Project:	Capitol Park, Barnsley: Air Quality Assessment	Job No:	60501921
Subject:	Air Quality Technical Note	Date:	13th September 2016

On 9th September 2016, an e-mail was received from Chris Shields, Technical Officer at Barnsley Metropolitan Borough Council, who provided the following comments in relation to the monitoring data presented in the report and requested that pollutant concentrations and impacts be predicted at additional receptors adjacent to the eastbound carriageway of Dodsworth Road. This Technical Note addresses these comments.

Appendix D: Location of Modelled Sensitive Receptors

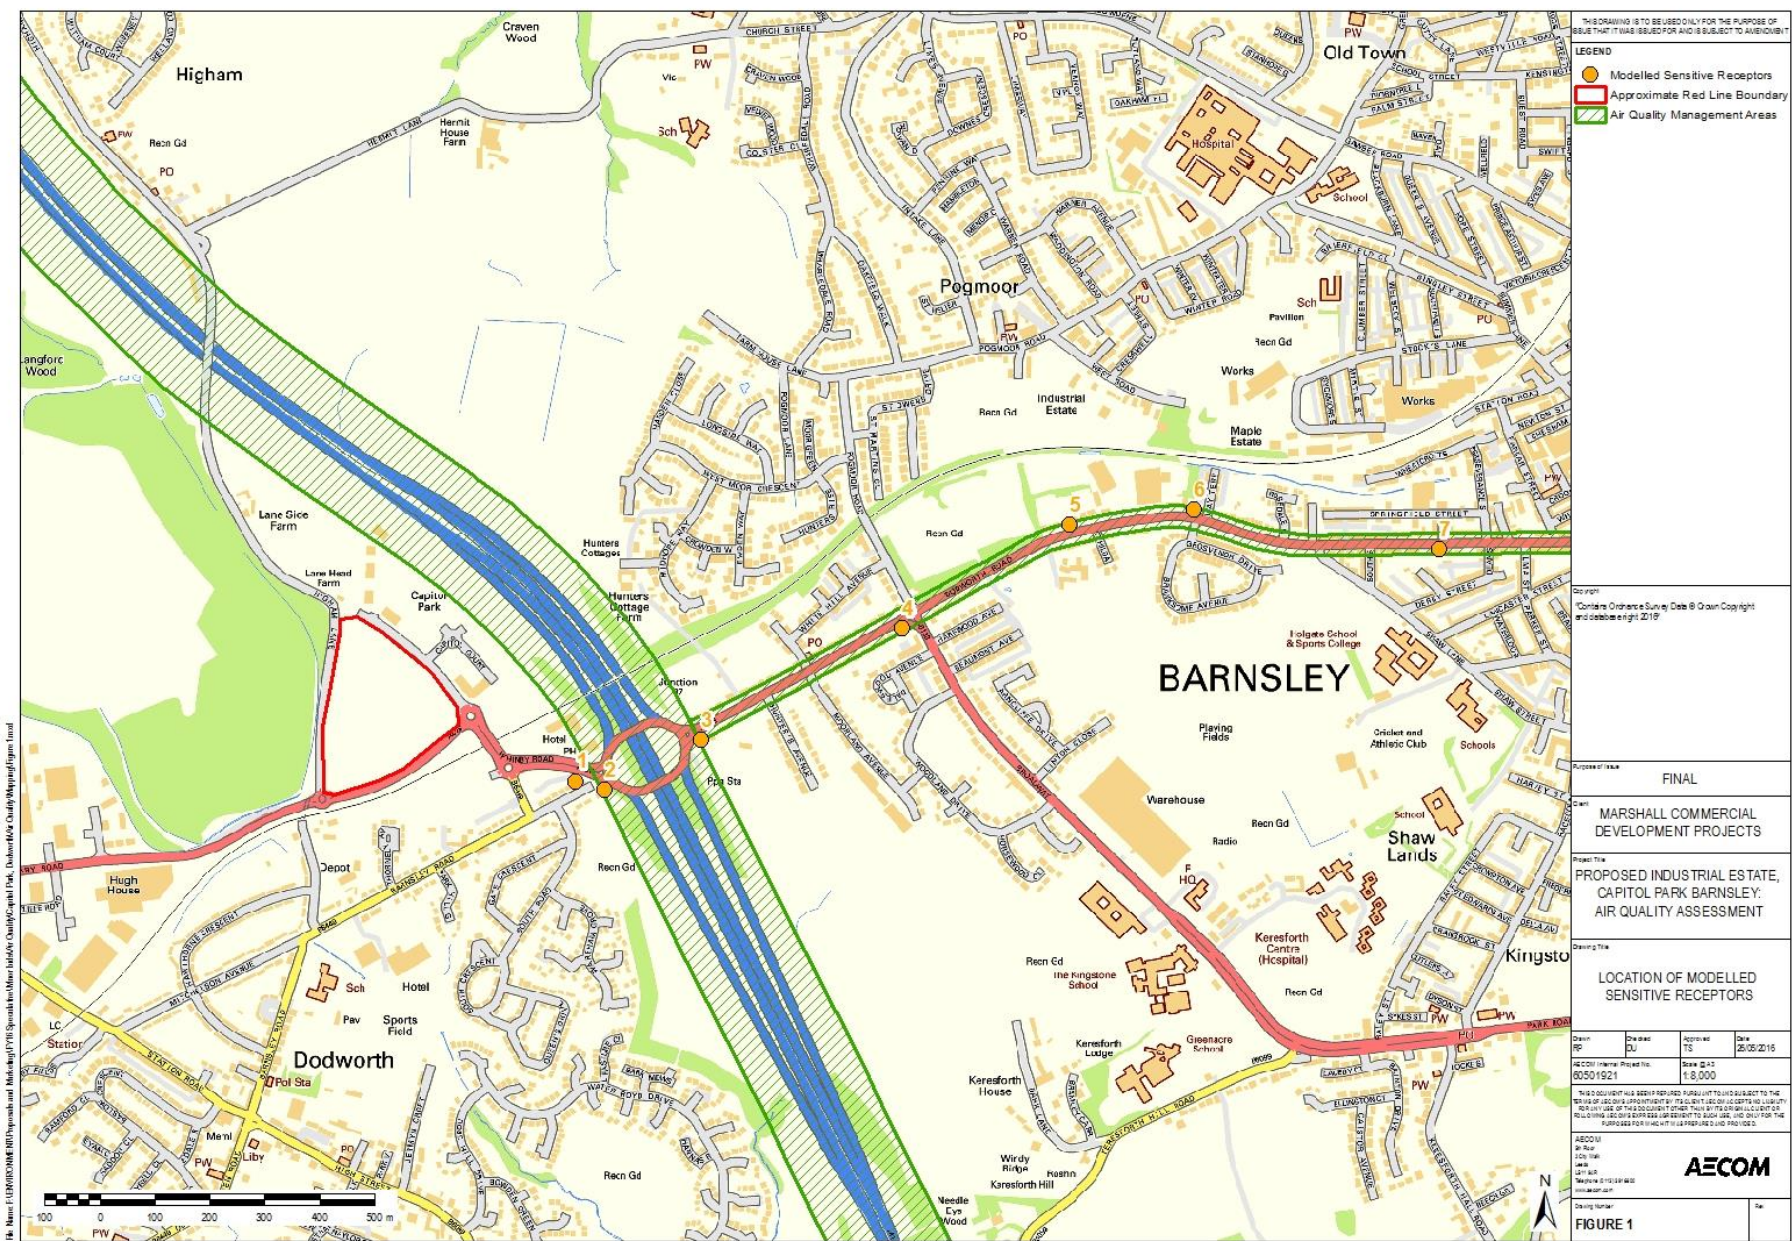
'I note from Appendix D: Location of Modelled Sensitive Receptors, that, for the A628 Dodworth Road link between M1 Junction 37 and Pogmoor Crossroads, you have chosen 2 receptor locations (locations 3 and 4 on the map within Appendix D), which appear to be adjacent to the westbound carriageway. From the diffusion tube data, the highest roadside concentrations between M1 Junction 37 and Pogmoor Crossroads appear to be at receptors adjacent to the eastbound carriageway. Therefore, would it be possible to provide data and assessment of significance for three receptors adjacent to the

eastbound carriageway (at least one of the receptors shall be close / at to 305-315 Dodworth Road where concentrations are highest)?'

As requested, additional receptors were selected adjacent to the eastbound carriageway of Dodsworth Road and pollutant concentrations were predicted for each of the scenarios described in Section 3.3 of the report.

Receptors 8, 9 and 10 are located at the façade of properties adjacent to Barnsley Metropolitan Borough Council diffusion tubes D80, D78 and D79, while Receptor 11 is located at the façade of a property near the Pogmoor/Dodworth road crossroads. The locations of these receptors are illustrated in Figure 1.
